RE: Breeze @ South Peak, W.O. # 641481, (J-22/D066)
Engineers Certification for Release of Financial Guaranty
Engineers Stamp dated 04/21/2000
Engineers Certification dated 06-03-11

**Re: Revised Drainage Plan for the Breeze at South Peak
Engineer's stamp 4-12-00 (J22/D66)**

Re: Breeze at South Peak Drainage Report
Engineer's Stamp dated 3-13-00 (J22/D66)

TITLE: **BREEZE AT SOUTH PEAK
GRADING AND DRAINAGE PLAN**

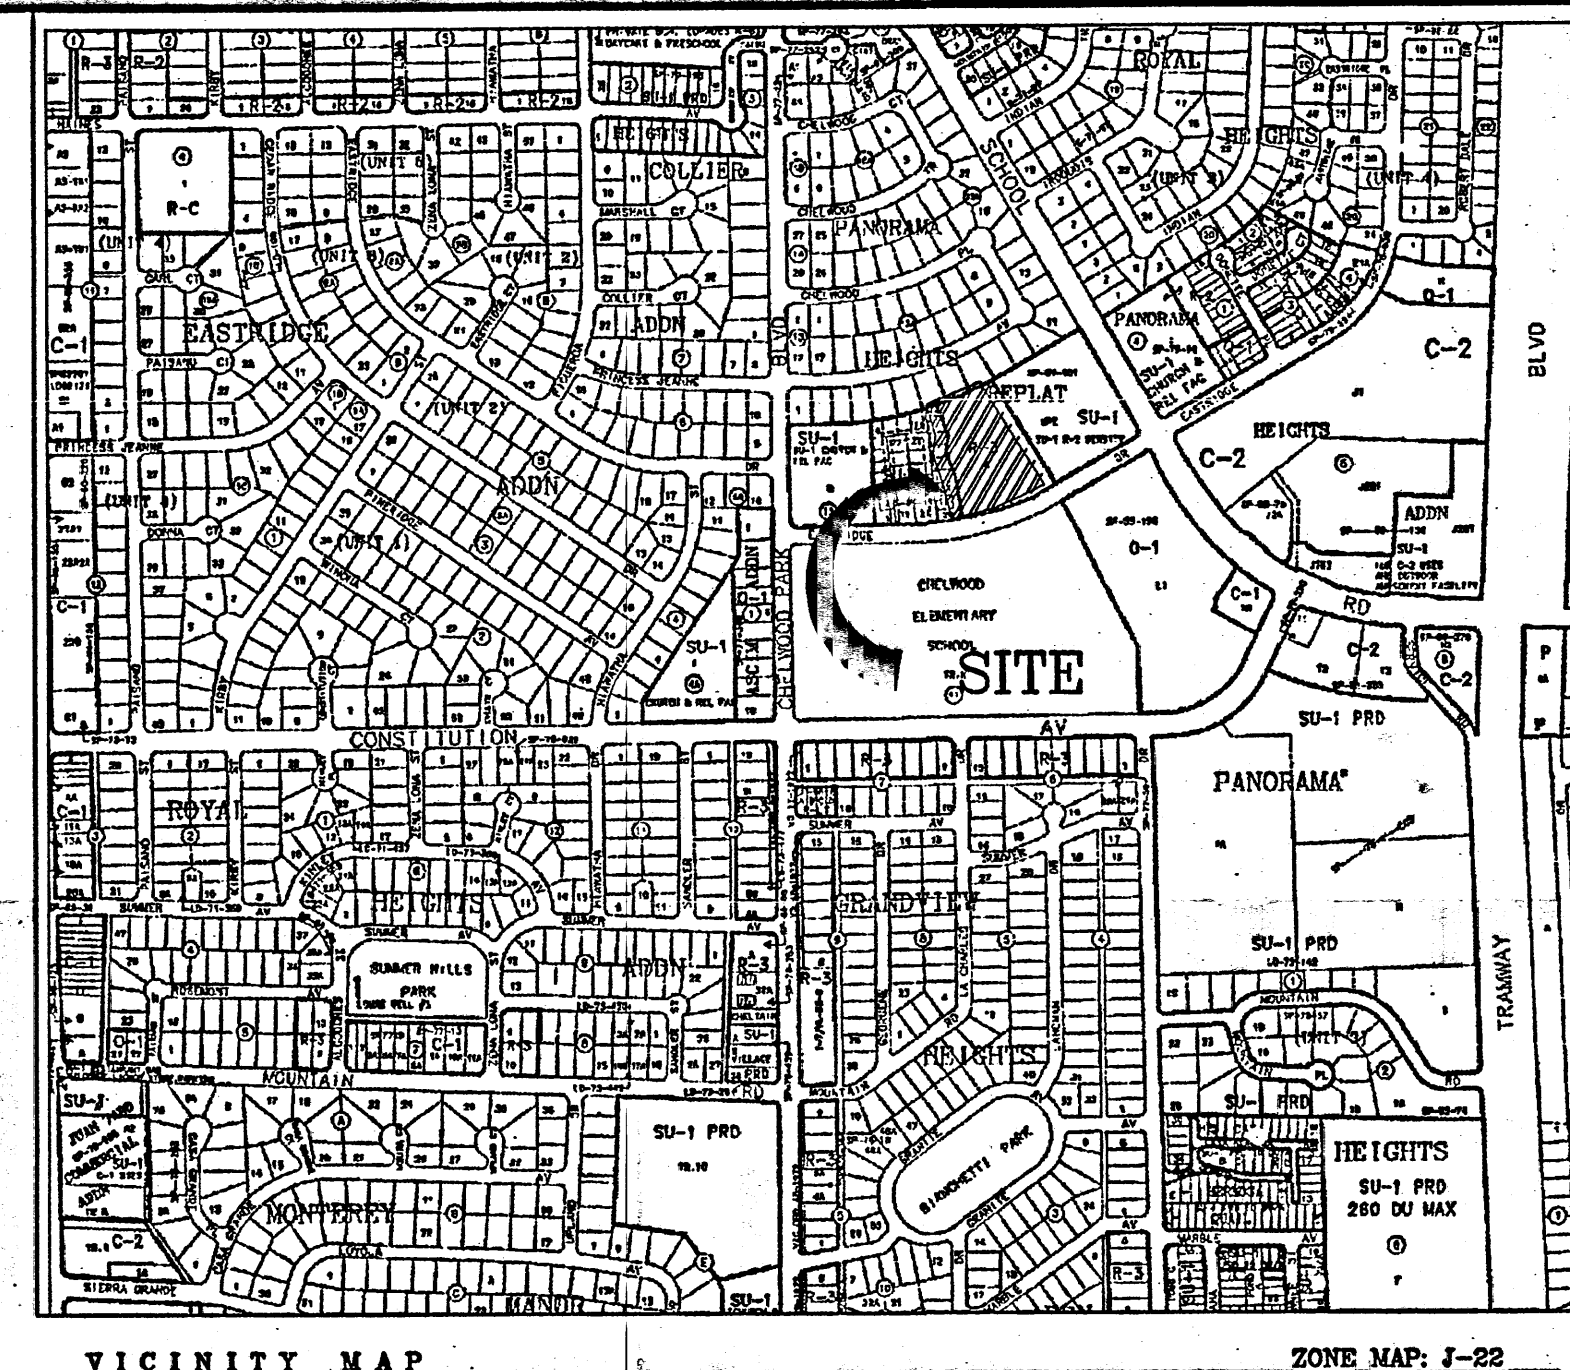
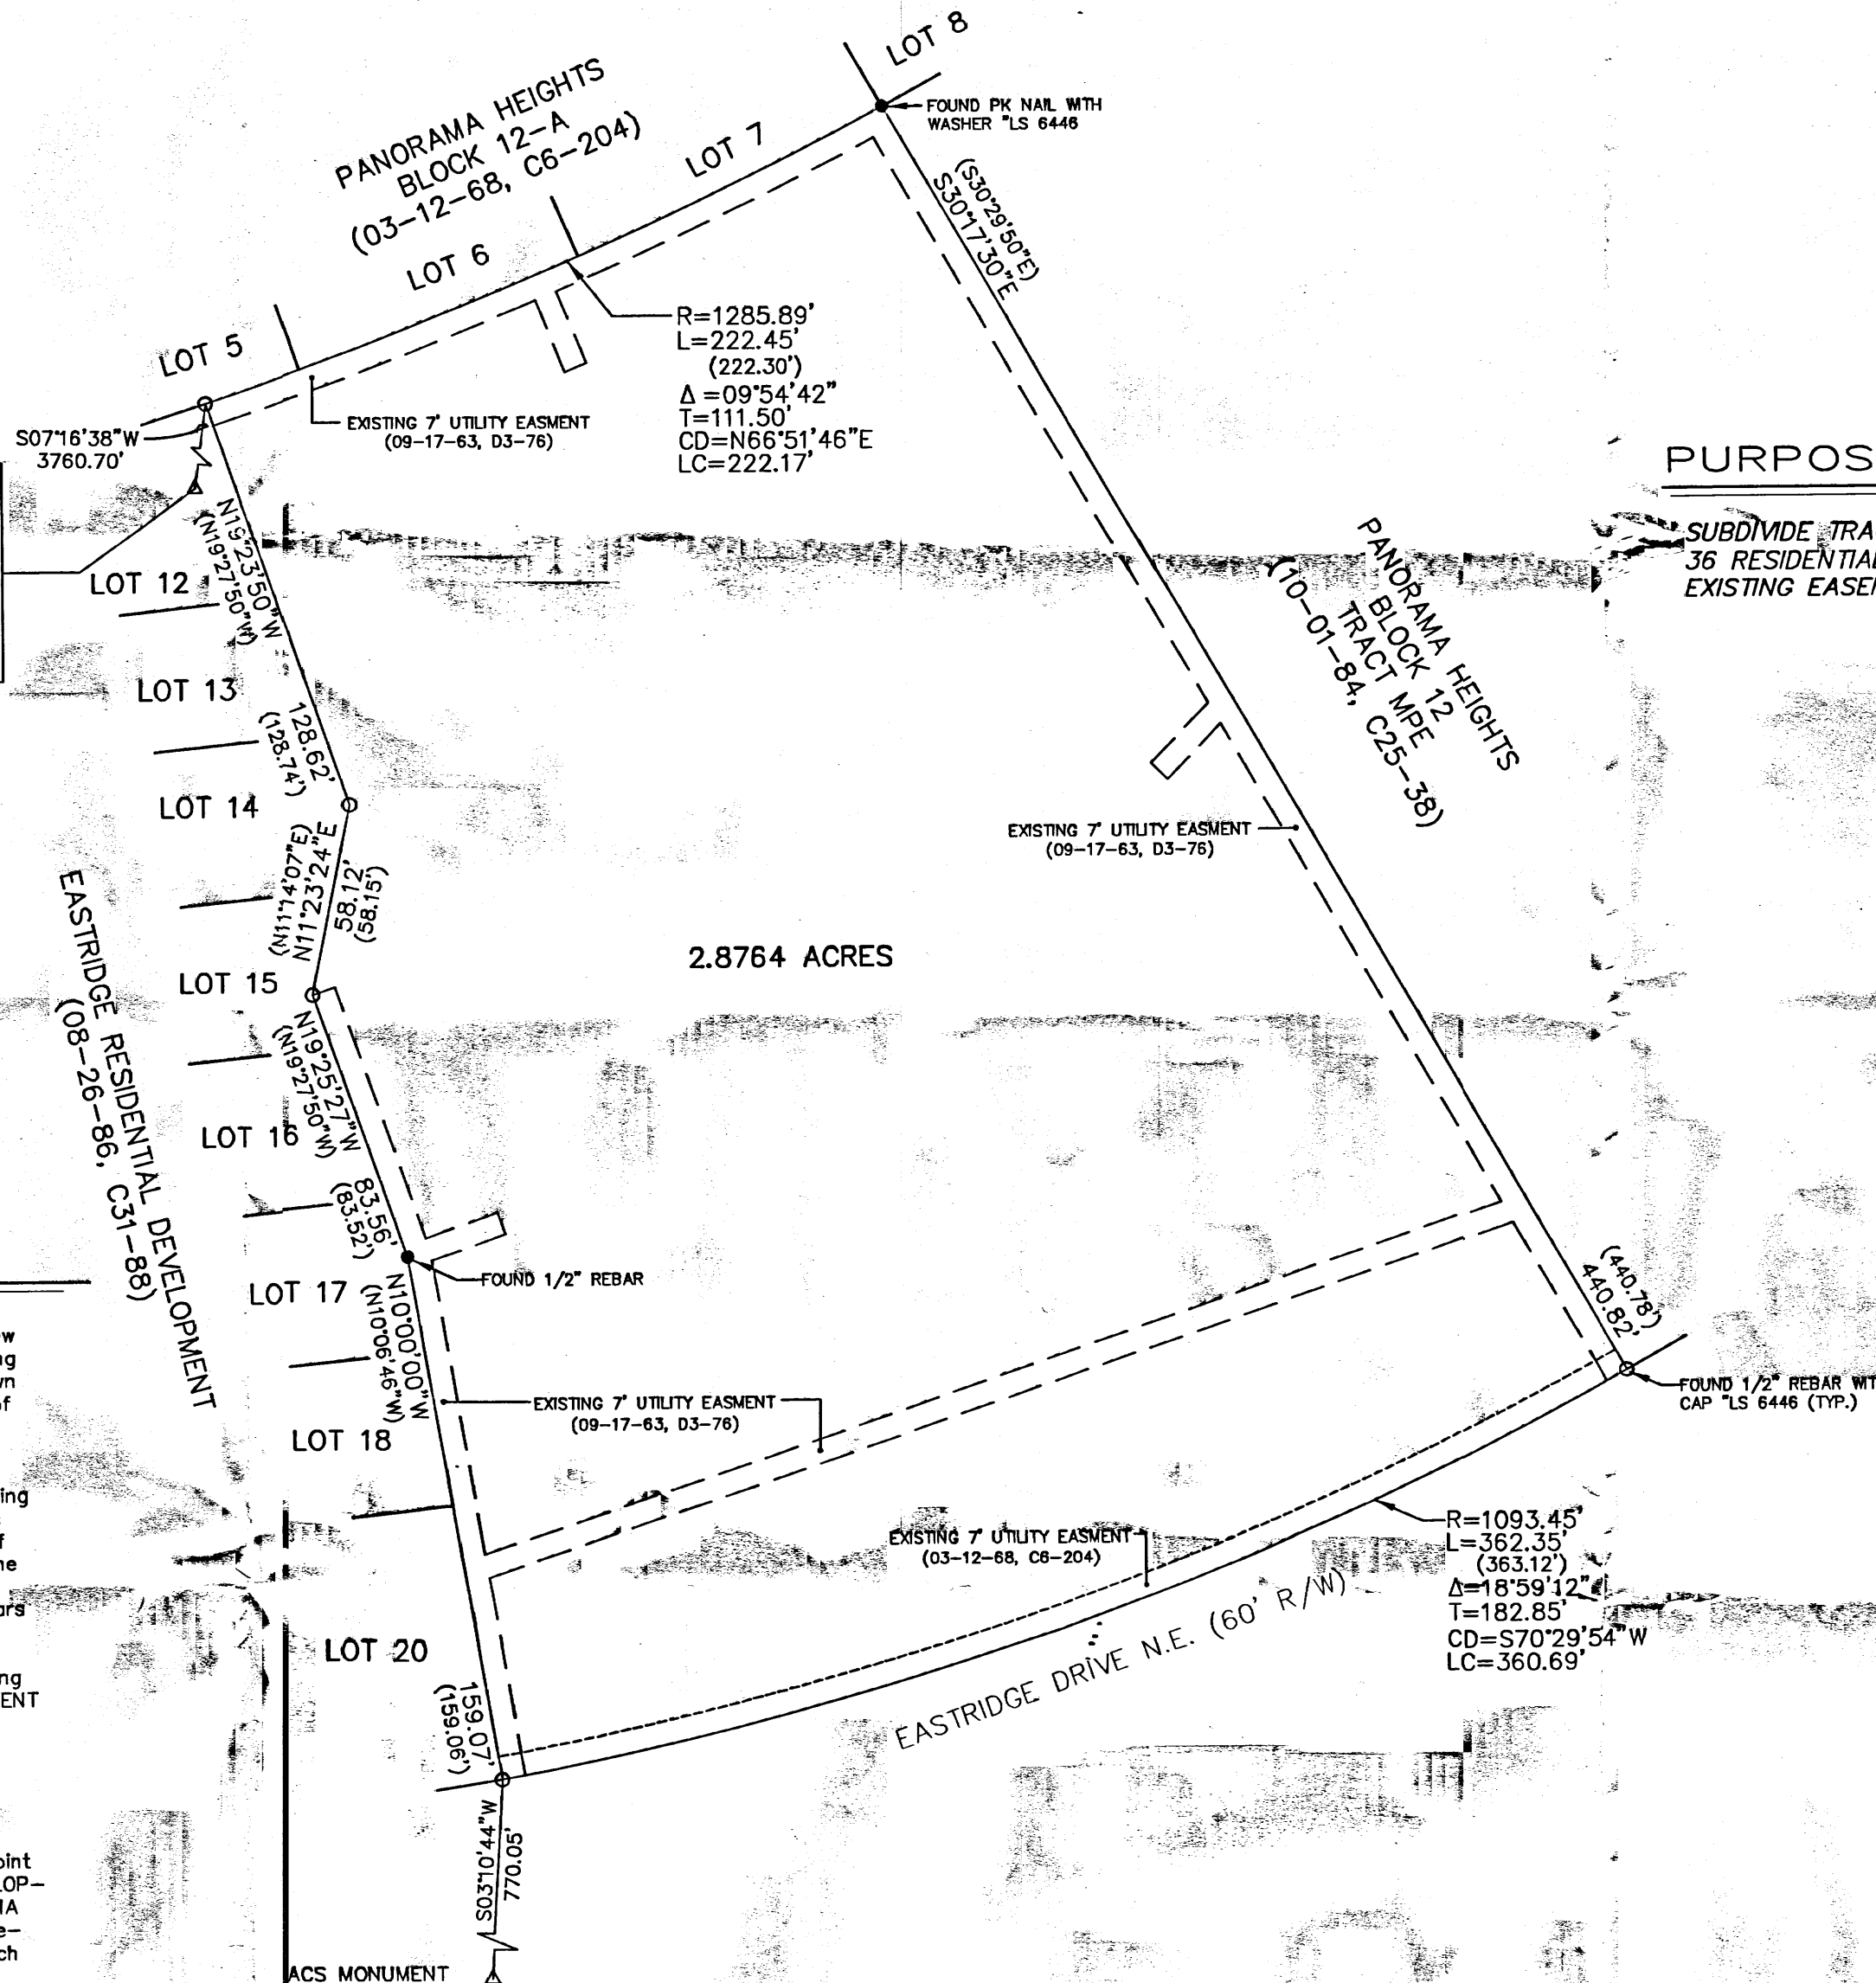
- What is finished pad elevation for lot 36? Does that lot have a backyard? Please show where the roof runoff from this and all other lots goes. As you know, all developed runoff is required to drain to the street.

- Is there supposed to be a retaining wall along the northwestern edge of lot 18? Also, does this lot meet the sideyard setback requirement for R3 zoning?

- Lots 13 & 14 appear to be squeezed into the project. I think this plan has a few too many lots. Are you planning on vacating the existing 7' PUE?
- Please provide street grades (longitudinal) for all streets on the grading plan.

- A retaining wall appears to be needed along the north side of Lot 19. This wall will be below the 1.5-foot threshold for a true retaining wall but a masonry wall

will be needed here. Please denote on the grading plan (with a different linetype) all areas that a 0-1.5' masonry wall would be needed. This will be a requirement on all future projects as well.

- Please add sub basin 4 (which includes Lots 1 and 27) to your summary table.
- Please add some additional spot elevations in the area across the street from lots 33 thru 28 to make sure that this area drains back to the street.
- Please add a handicap ramp to western entrance.

1. A finished pad elevation on lot 36 is indicated on the G&D plan. This lot has a side yard only. Roof drainage to the front yard is indicated on the revised G&D plan as a general note and as a symbol on each pad.

2. A retaining wall has been added along the northwestern edge of Lot 18 along with the proper 5' side yard setback.
3. A 5' sideyard setback has been added to lot 14. The G&D plan has been revised to clearly show which PUE are being vacated. I am actively coordinating with PNM on vacations of these easements.

4. Preliminary street slopes are indicated on the revised G&D plan.
5. While 4:1 slopes may be more desirable, 3:1 slopes are the accepted City standard minimum. Backyard ponding detail A-A has been modified to accommodate your concern.

6. A retaining wall along the north side of Lot 19 is not necessary. 3:1 side slopes can be maintained down to the public right-of-way. In response to your concern regarding 0-1.5' masonry walls a general note has been added to the G&D plan.

7. Subbasin 4 has been added to Exhibit 2.
8. Additional spot elevations along the western property line have been added.
9. Handicap ramp has been added to the western entrance road.

TYPICAL BACKYARD GRADING DETAIL A-A
NTS

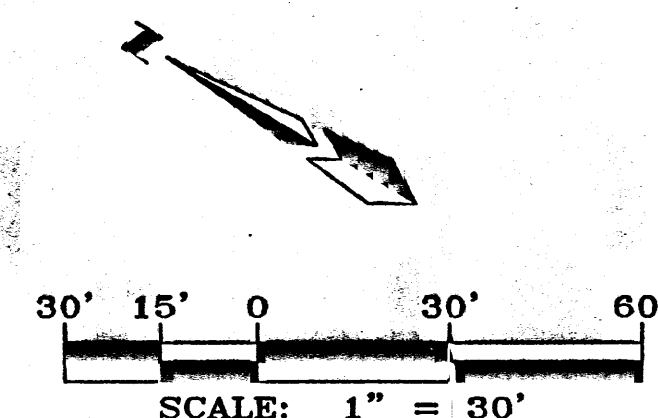
- Backyards with a 3:1 slope are essentially unusable. I would prefer to see no steeper than a 4:1 slope. In addition, ponding against the retaining wall is not acceptable due to the seepage thru the wall that would occur, not to mention that the pond would fill in the first time the wind blew. Please redesign with appropriate wall heights and/or a hard-lined backyard channel that drains to Eastridge or the internal street. Please include a copy of the Preliminary Plat and Infrastructure List with your resubmittal.
